Approval of details reserved by condition imposed under ref CM/51/20/L relating to Condition No 1 - schedule of materials and finishes to be used for external walls and roofs.

Kents Farm House Brookpit Lane Climping BN17 5QU

Arun District Council have decided to **REFUSE** details reserved by condition for the following reasons:

Dwg No.
112/168/11

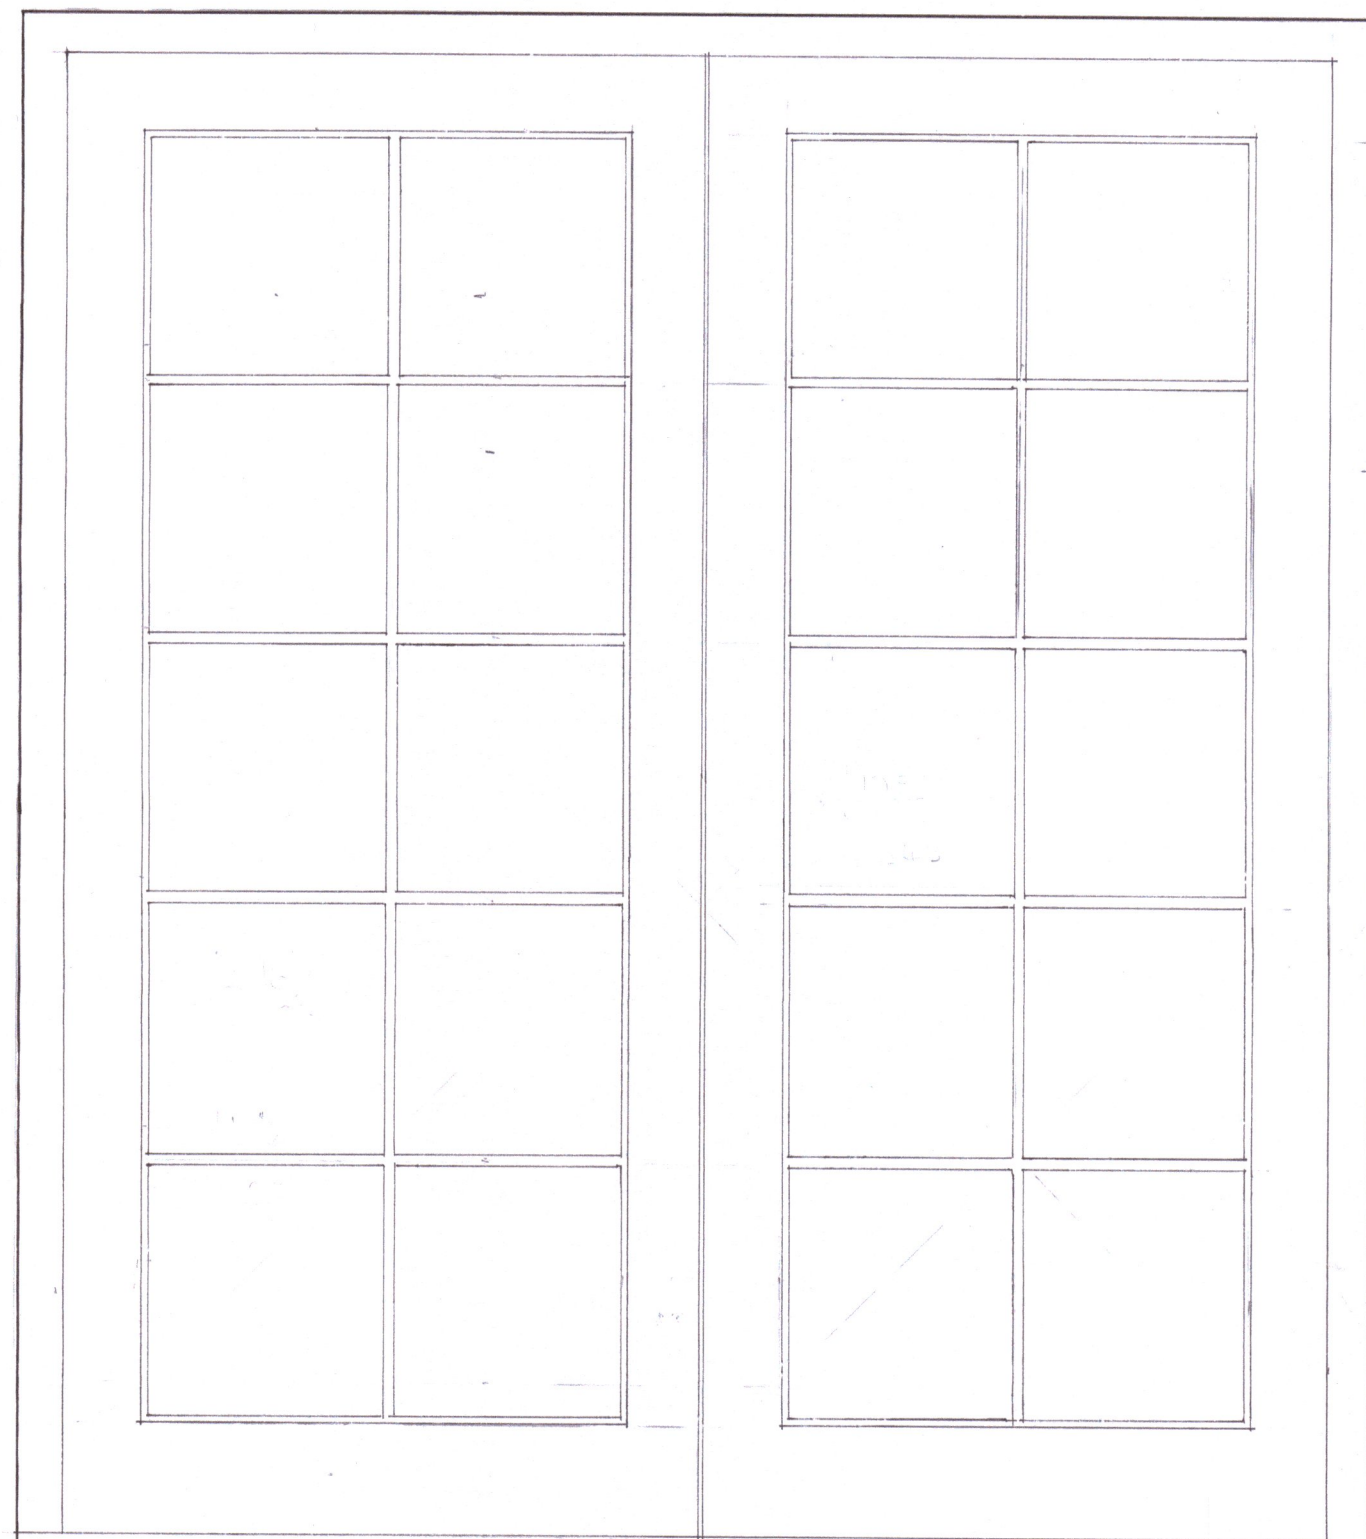
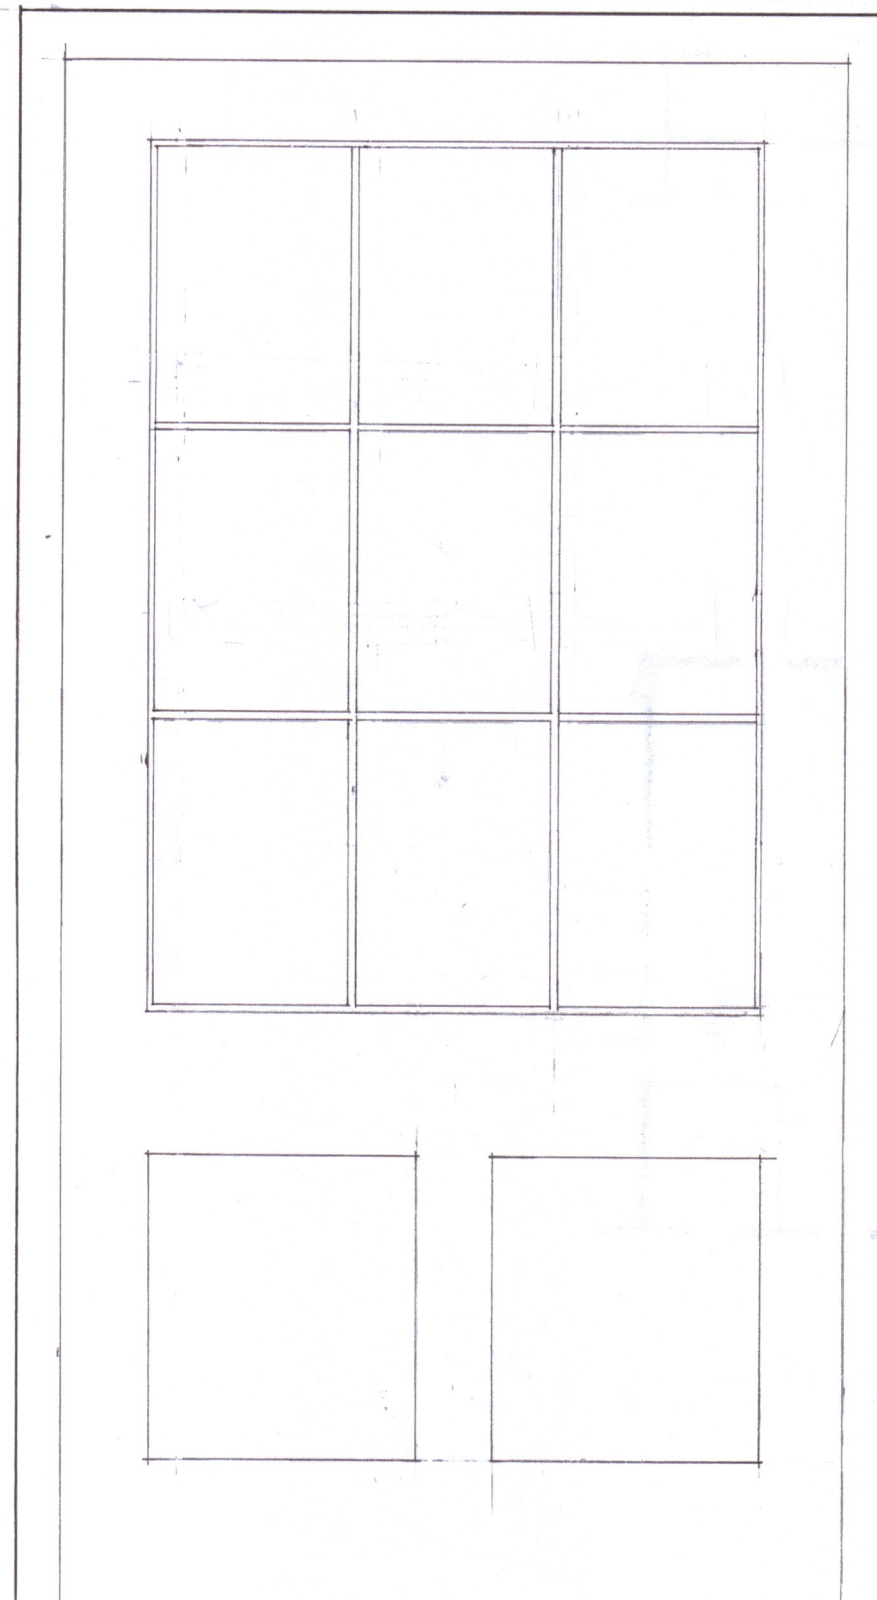
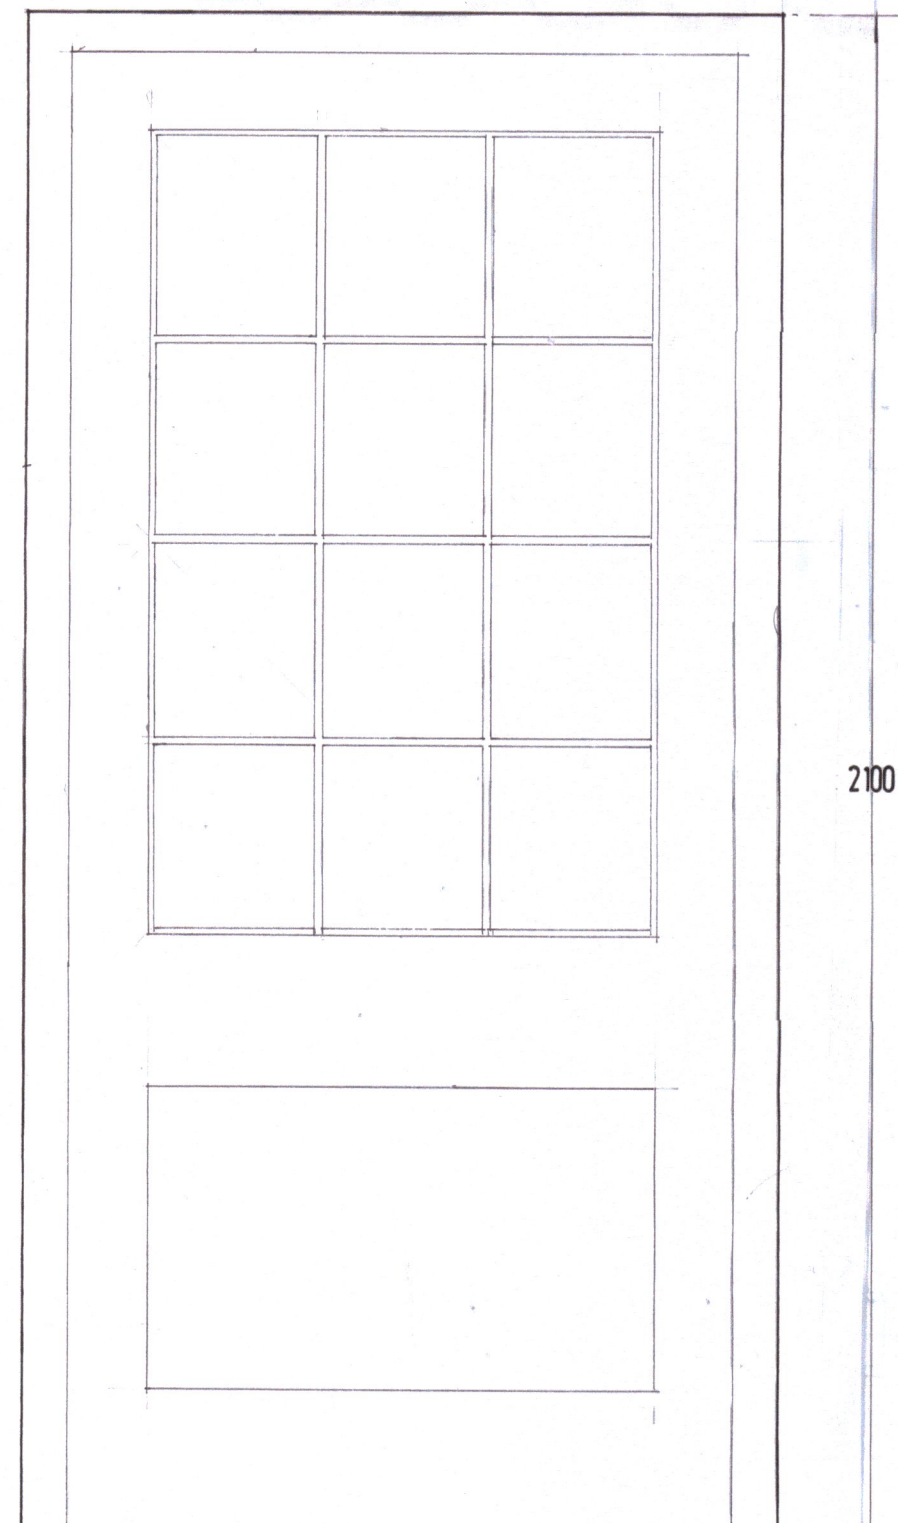
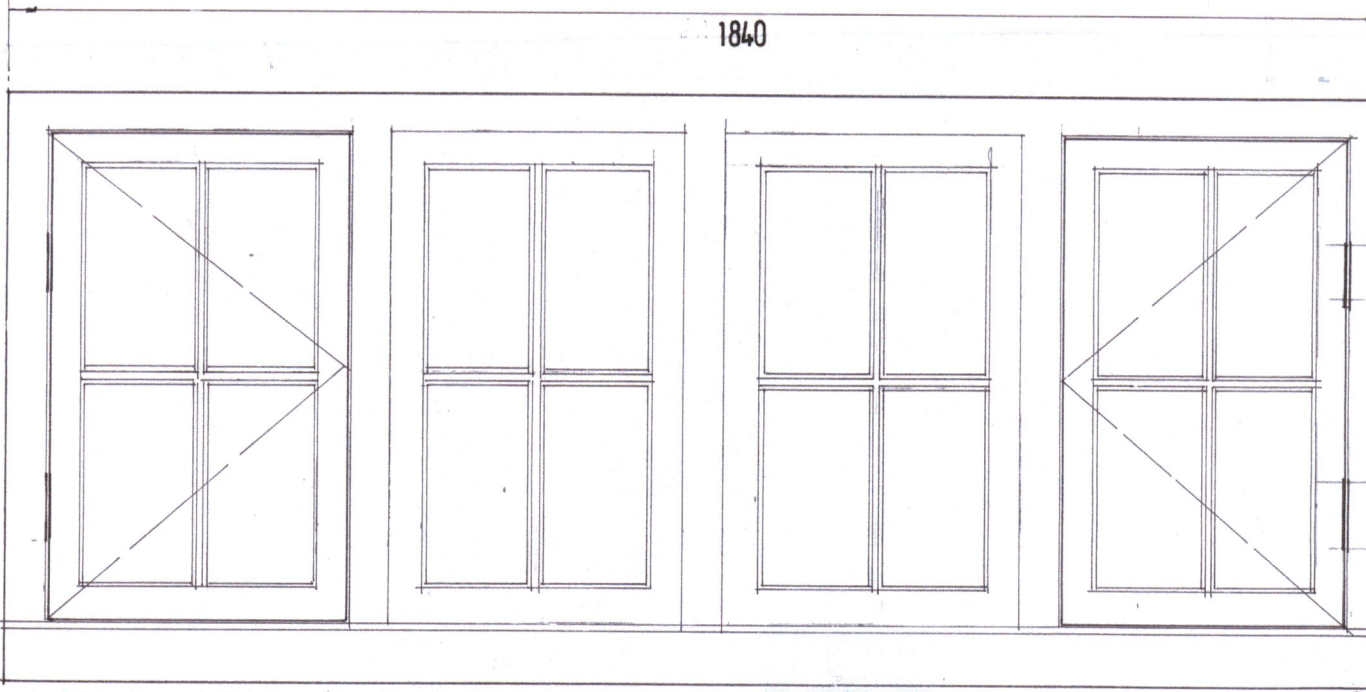
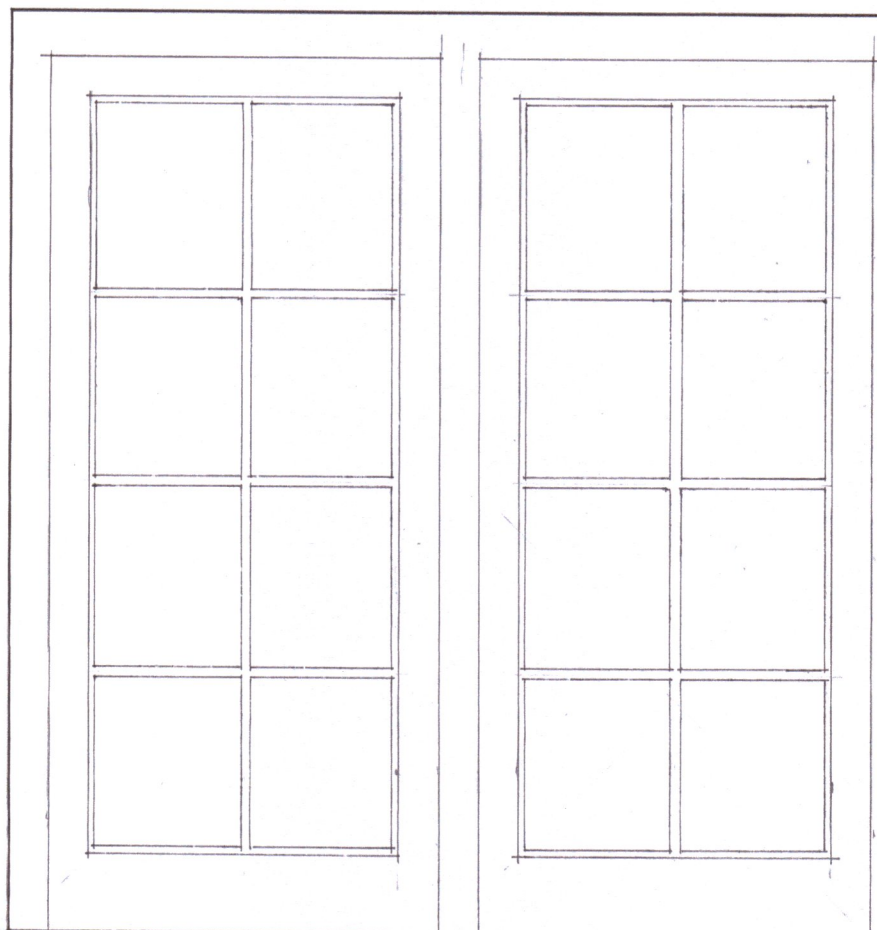
'As noted in previous comments on DOC applications, and unfortunately, also noted here as well, the drawings of the windows identify that 'standard' (24mm) double glazed units are to be used for the new/replacement windows. As previously noted, this is not acceptable. If double glazing is to be accepted, it will have to be the slimmer heritage style. However, the cover letter contradicts the plans stating the windows will be single glazed. Please can the glazing be confirmed.

Draw No.
112/168/6

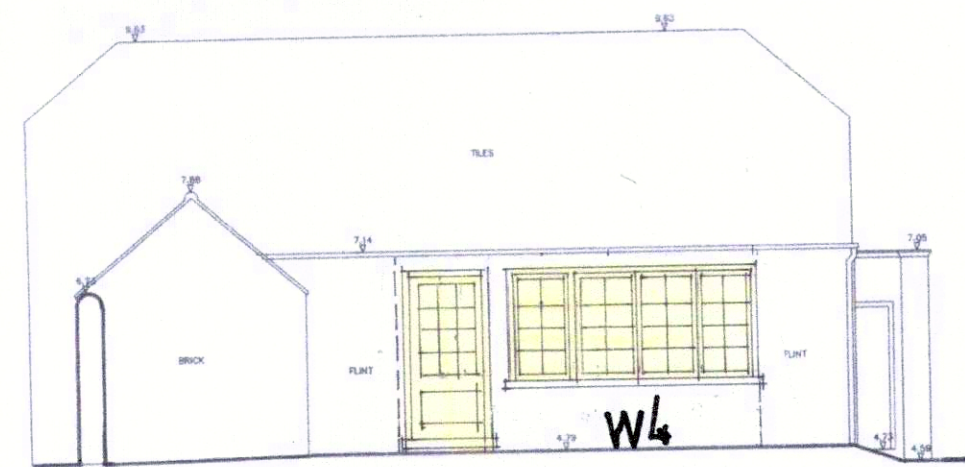
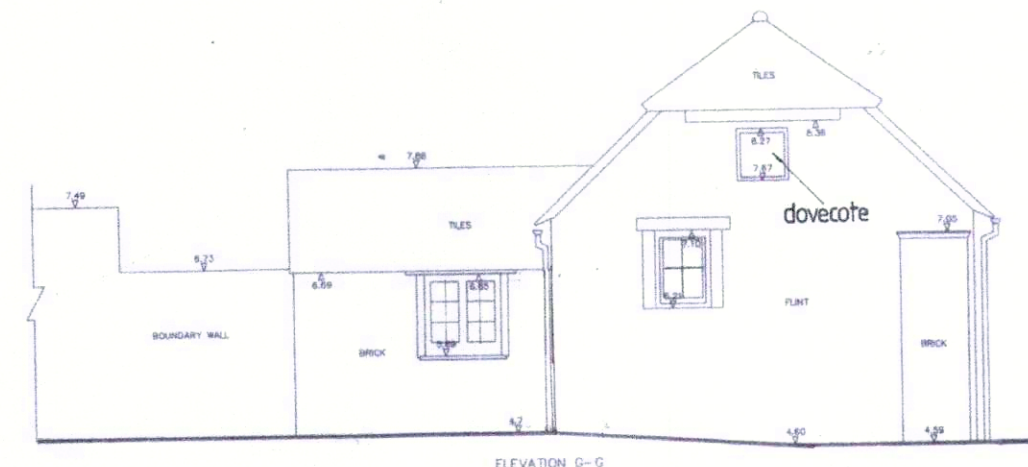
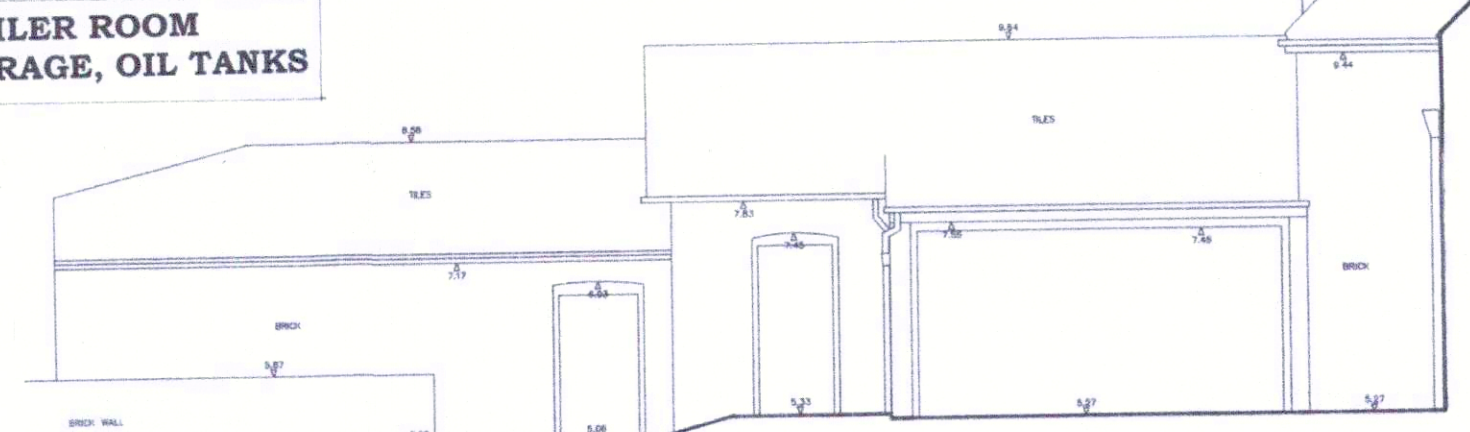
I also note a reference to the fact that the boiler has been removed to an 'outbuilding with no listed building significance'. Please can the location be confirmed as the outbuilding may still be classed as curtilage listed?
